Subject: Formal Objection to Residential Flat Development - Sanderling Avenue Hawks Nest

Project: Residential Flat Development

Address: Sanderling Ave Hawks Nest NSW 2324

Reference: SSD-82066472

HAWKS NEST RESIDENTIAL DEVELOPMENT : SECTIONS

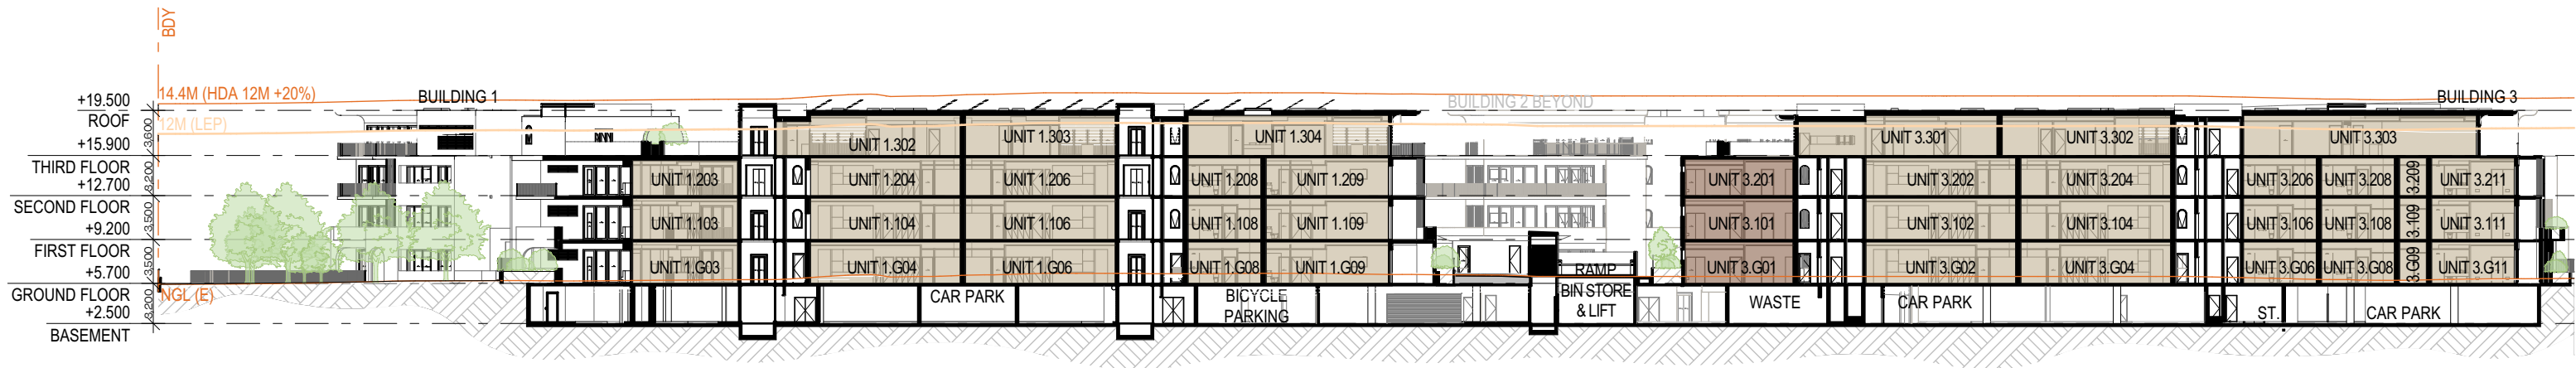
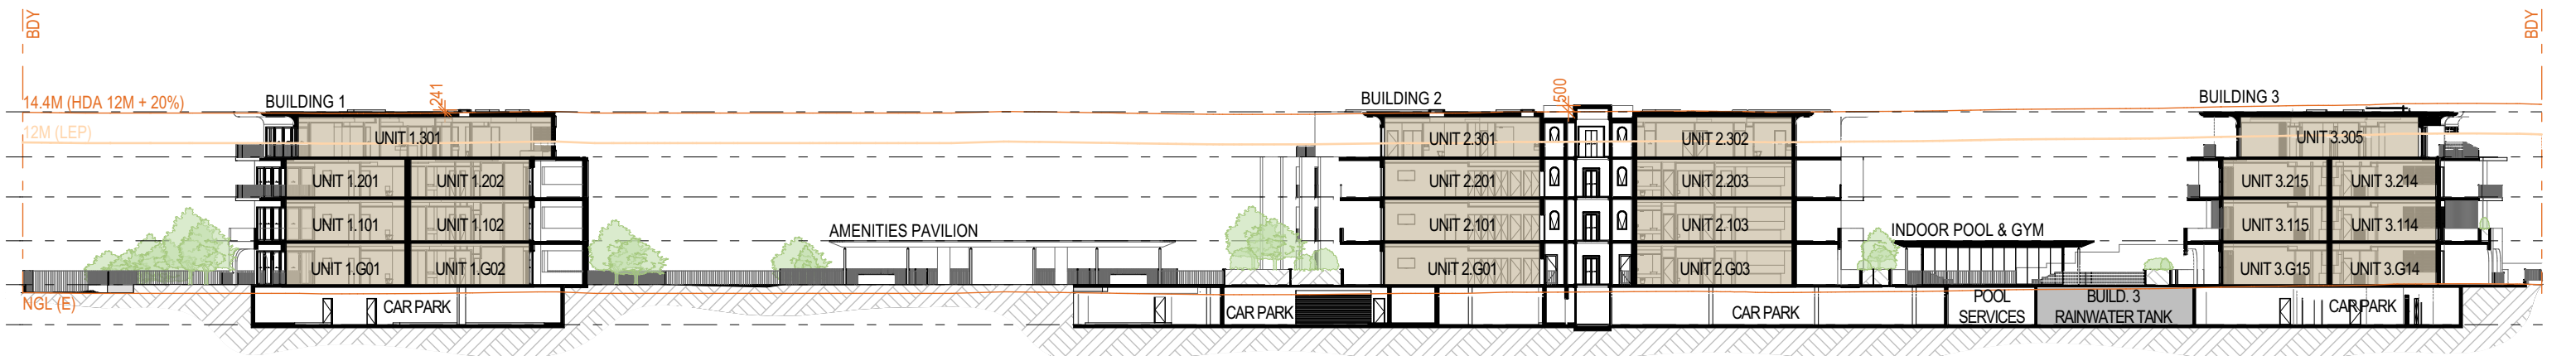
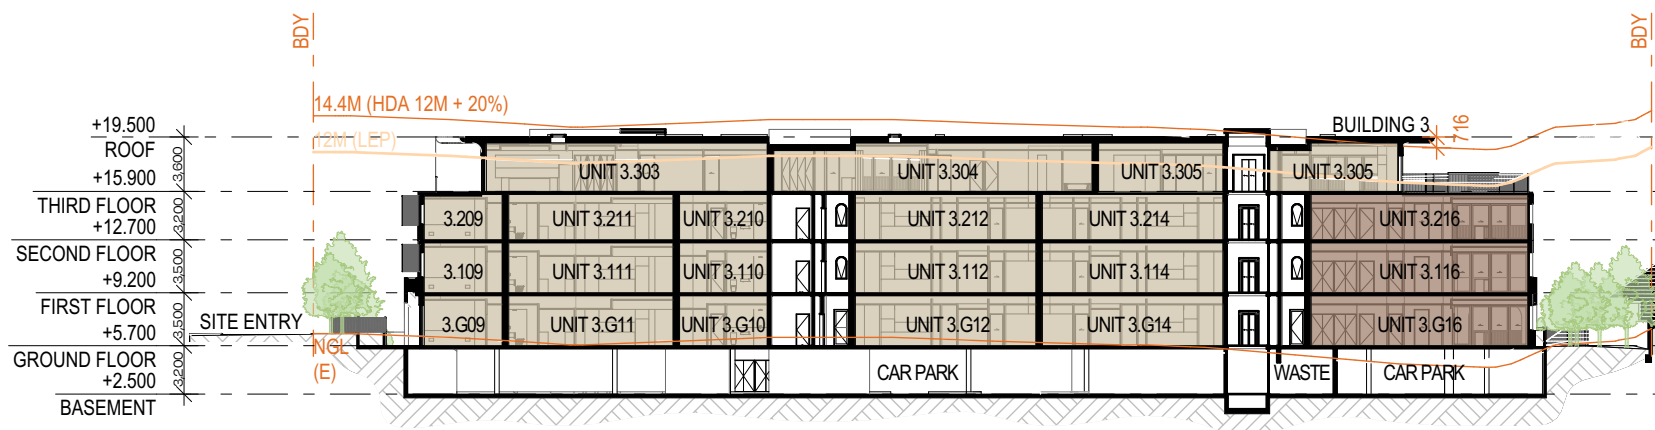
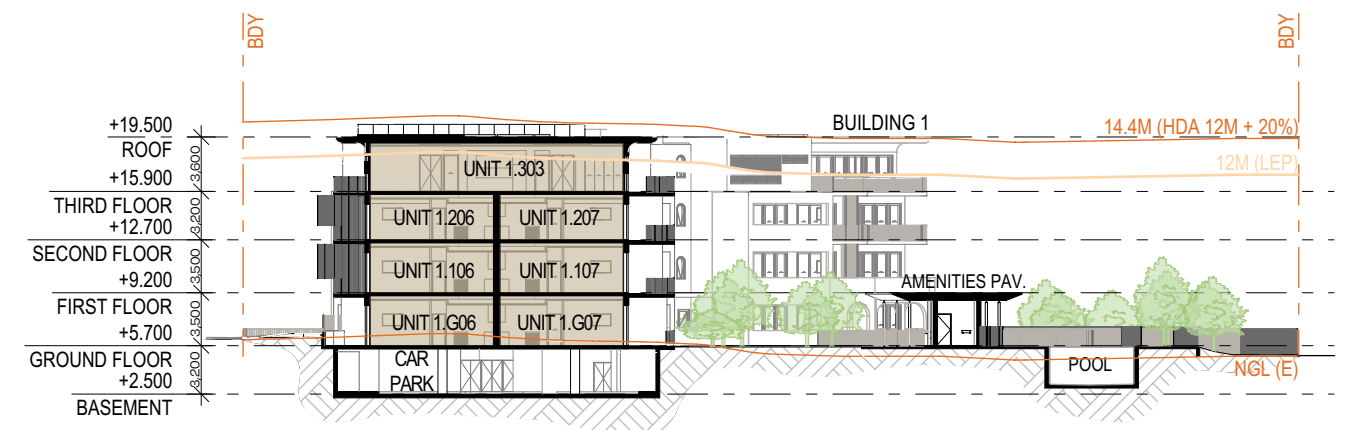
The proposal comprises three four-storey residential flat buildings containing 104 dwellings, with proposed building heights ranging from approximately 14.4m to 15.25m, exceeding the applicable 12m height limit by approximately 20–27%.

The applicant seeks a Clause 4.6 variation to exceed the mapped maximum building height control. However, the variation appears primarily driven by development yield and apartment numbers rather than genuine site constraints or exceptional planning circumstances.

The proposal has not adequately demonstrated why a compliant 12m scheme could not achieve an appropriate residential outcome on the site. A desire to maximise development yield should not outweigh the intent and integrity of the planning controls.

- Respecting the 12m height control
- Reducing visual bulk and scale
- Improving landscape integration
- Reducing infrastructure impacts
- Providing a more appropriate response to the established coastal character of Hawks Nest

For these reasons, I respectfully request that the Department refuse the application in its current form, refuse the Clause 4.6 variation request, or require substantial redesign to achieve a more contextually appropriate and compliant development outcome.
